TECHNICAL NOTE			
from:	ALAN DAVIES	date:	11/6/2021
subject:	<b>PROPOSED CONVERSION OF EXISTING BARN EIGHT DWELLINGS, BROCKHALL FARM GLENEAGLES DRIVE, BROCKHALL VILLAGE</b>	file ref:	J1194-TN1

This Technical Note sets out the response to the highway feedback.

Client	Brockhall Farm		
Project	Brockhall Farm redevelopment		
Title	Access mitigation		
Purpose of Issue	<input type="checkbox"/> For Information <input checked="" type="checkbox"/> Preliminary		
Drawn	AJC	Checked	AD
Scale	A4 Plot 1:500	Date	7/1/2021
Drawing No.	J1194 access fig 2	Rev

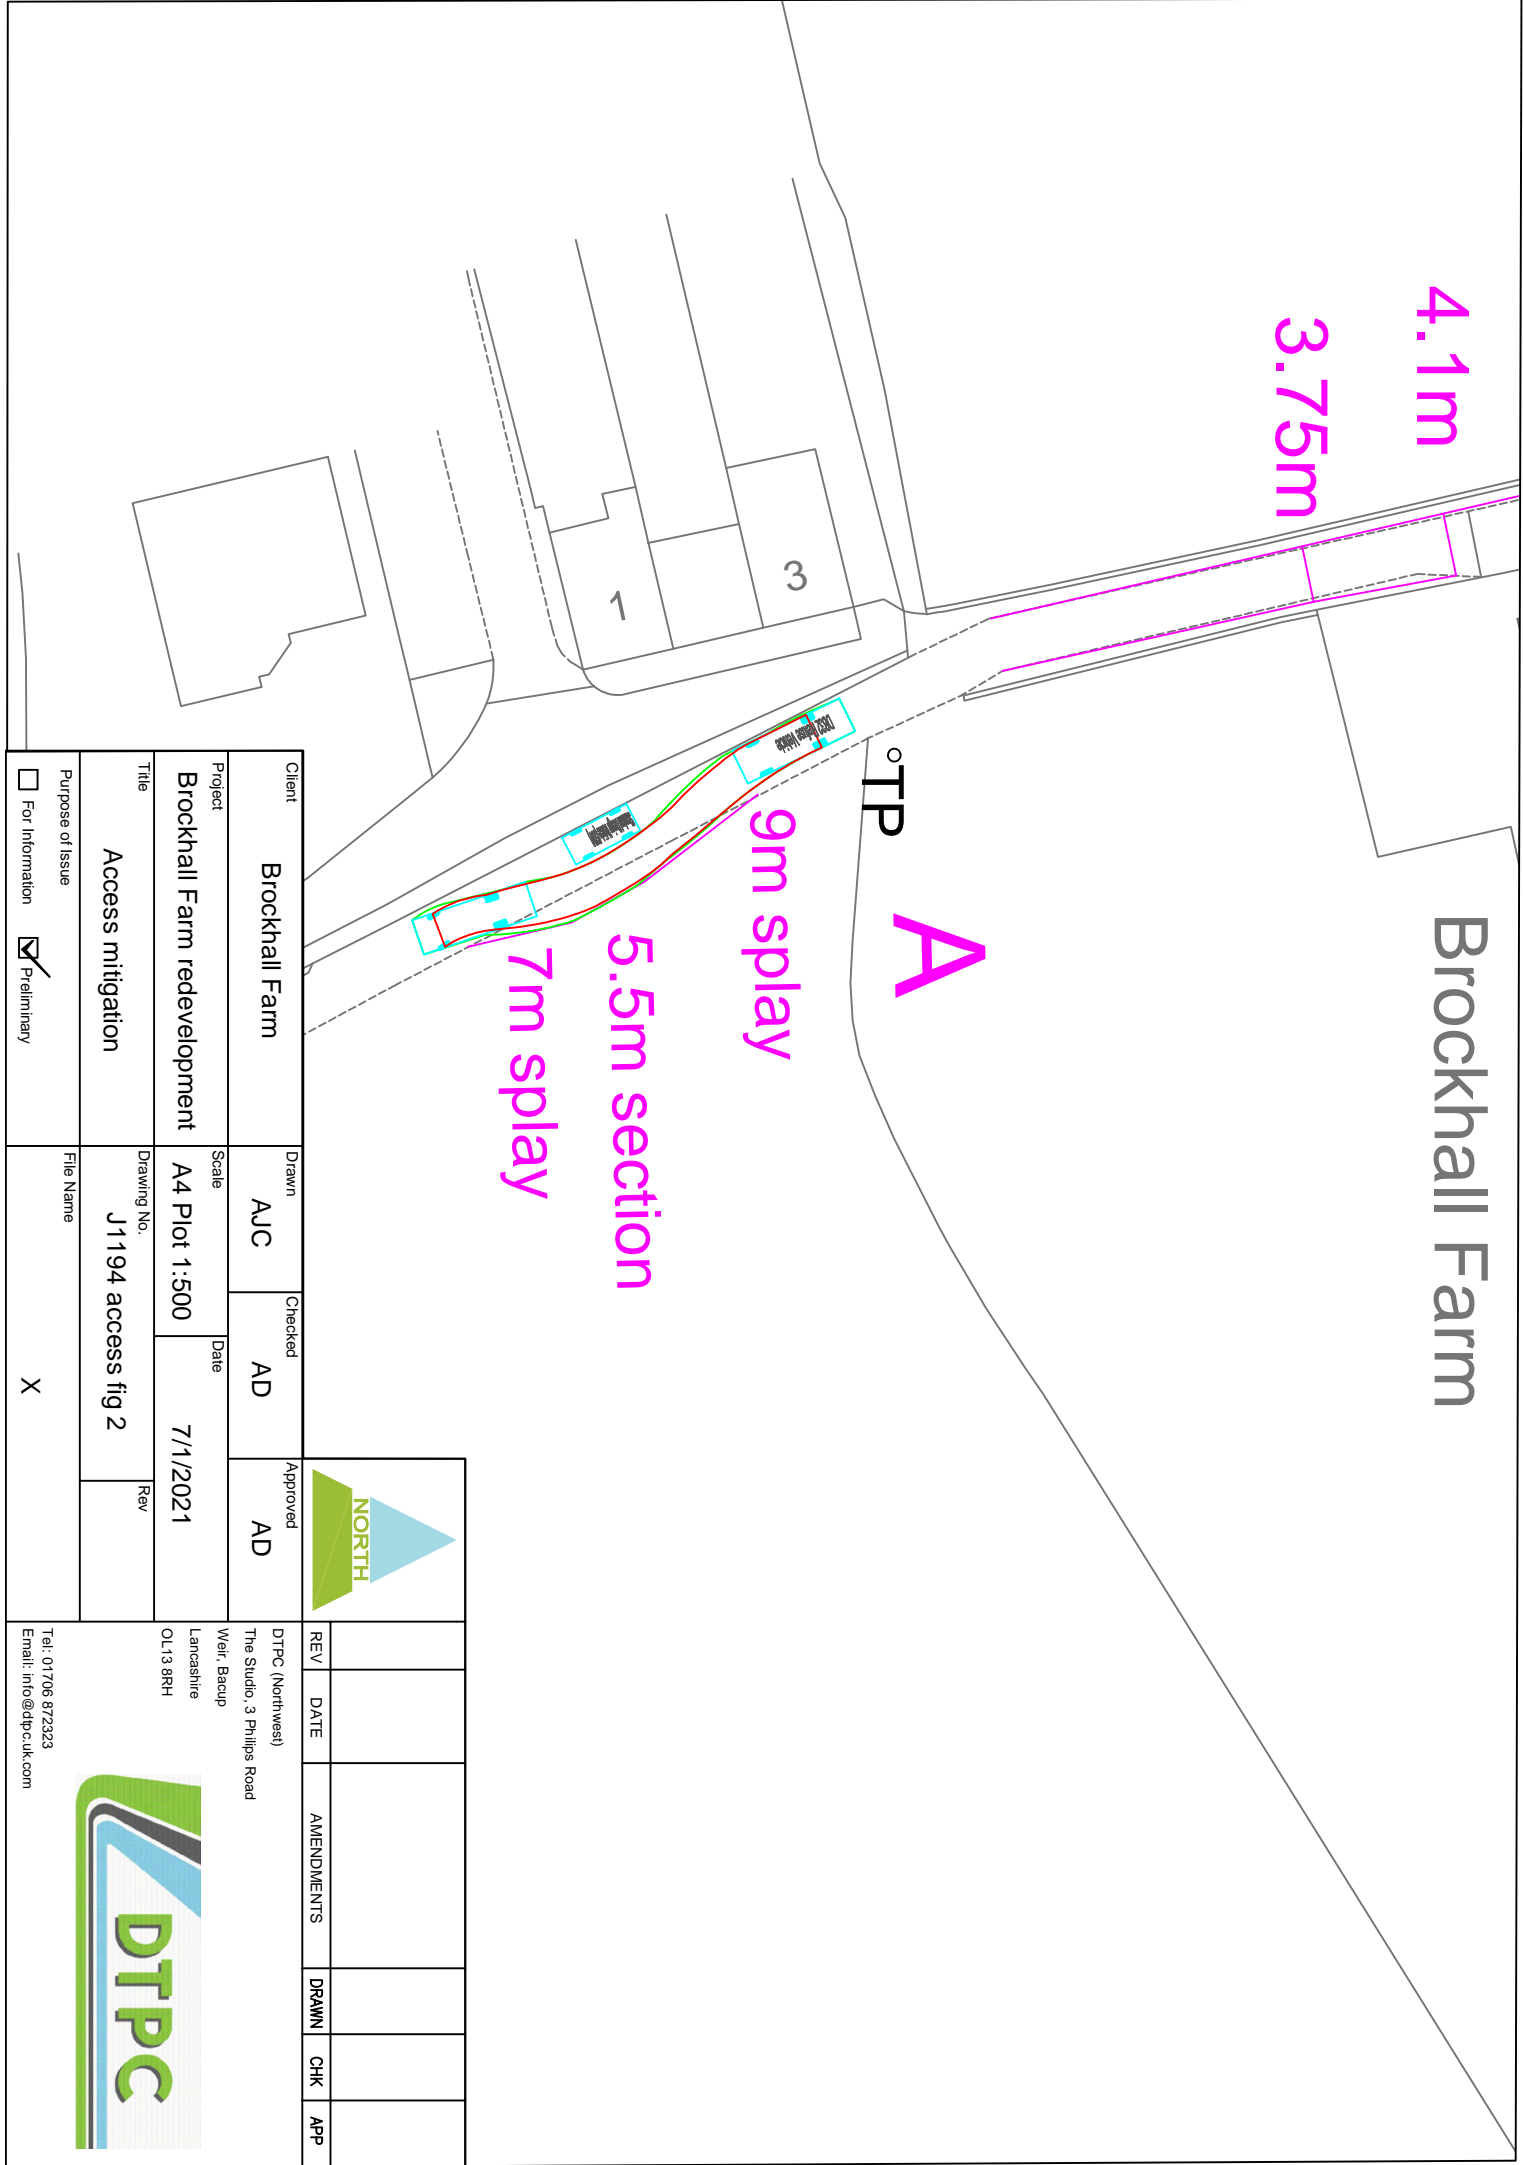
*Whilst a swept path analysis has been undertaken for a refuse collection vehicle for the passing places, there is no indication as to if the rest of the land is to be farmed. It is advised that the passing places should be of sufficiently large enough to accommodate the passing of tractor with trailer and the refuse vehicle.*

*An additional passing place should be considered at the start of access track adjacent to 25 Larkhill.*

**The laybys accommodate the proposed road-based users of the new buildings i.e., cars/vans/refuse. Farm vehicles can and do, if necessary, drive on or across the filed if required as such do not need to be accommodated in the lay by.**

**The access to the farm/development is alongside existing residential units and via a route that is private and not adopted. Access rights are part of the land deeds as is a level of shared maintenance.**

The following map shows the central area where access to drives/refuse turning for existing uses takes place.

The plan overleaf shows the central area in more detail and a 4.1m width in a dotted line.
